The Aldwick Bay Estate

31 Apple Grove, Aldwick Bay Estate.

Ref AW/101/15/HH

"Single storey extension to replace conservatory, new front dormer, reduce width of front dormer, new pitched roof to existing rear dormer & 2 No obscure glazed side windows."

Proposed Elevations

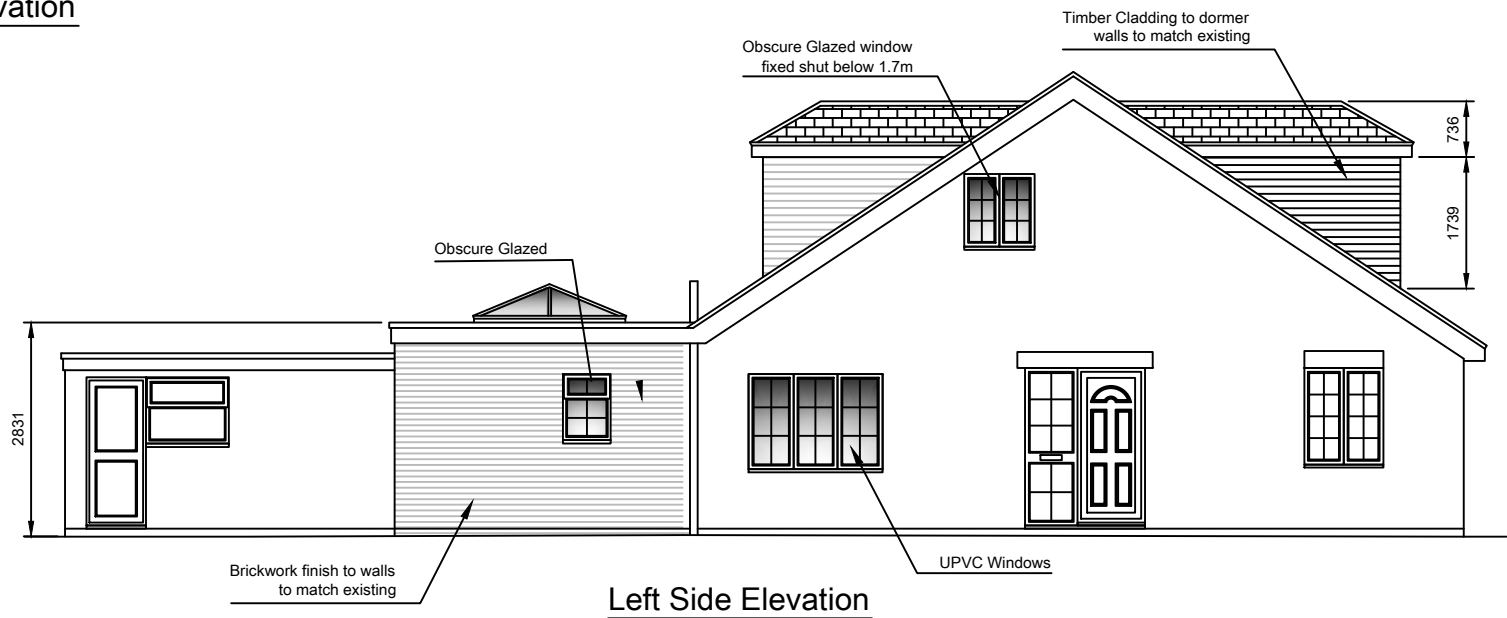
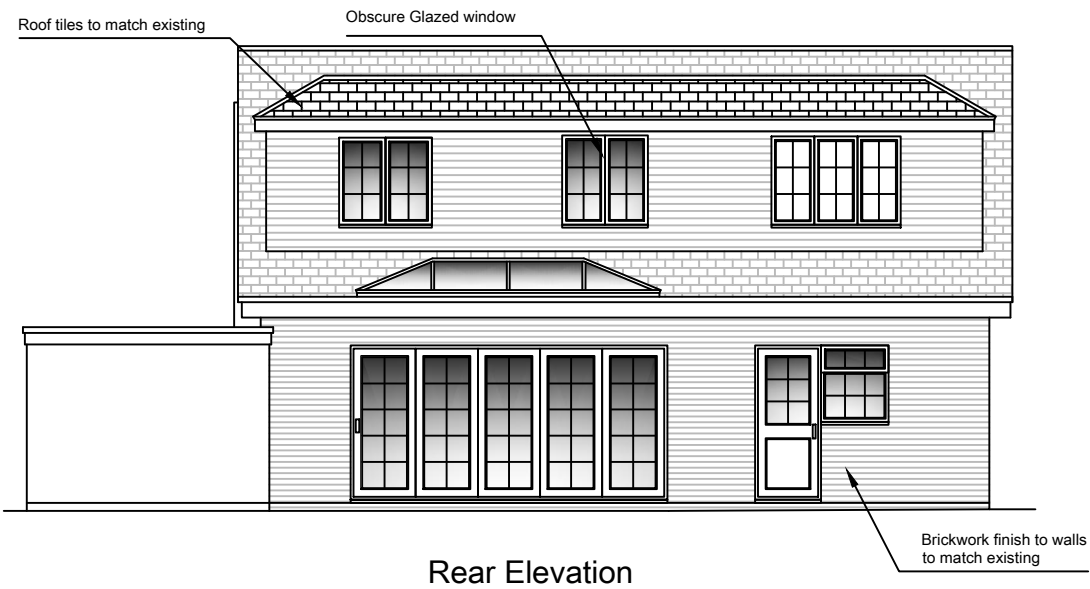
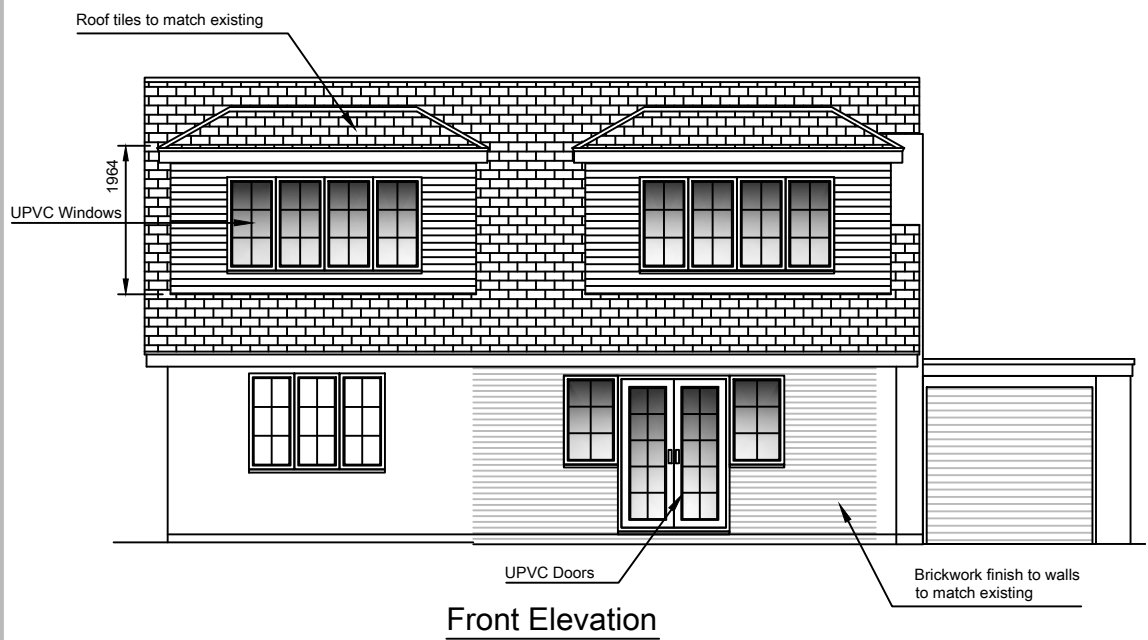
1. The design of the front dormers with windows that are larger than those on the ground floor together with the skirted tiled roof makes for a top heavy, 'too much going on' first floor. The whole could be improved by way of a simpler roof construction to the dormers and splitting the each windows into 2 or 3 smaller ones.
2. And with reference to the new windows in the left side elevation (facing west, 30 Apple Grove) we note that no dimensions to the boundary are shown. Please note that these may give rise to a Building Regulation problem concerning, unprotected areas/space separation in case of fire.
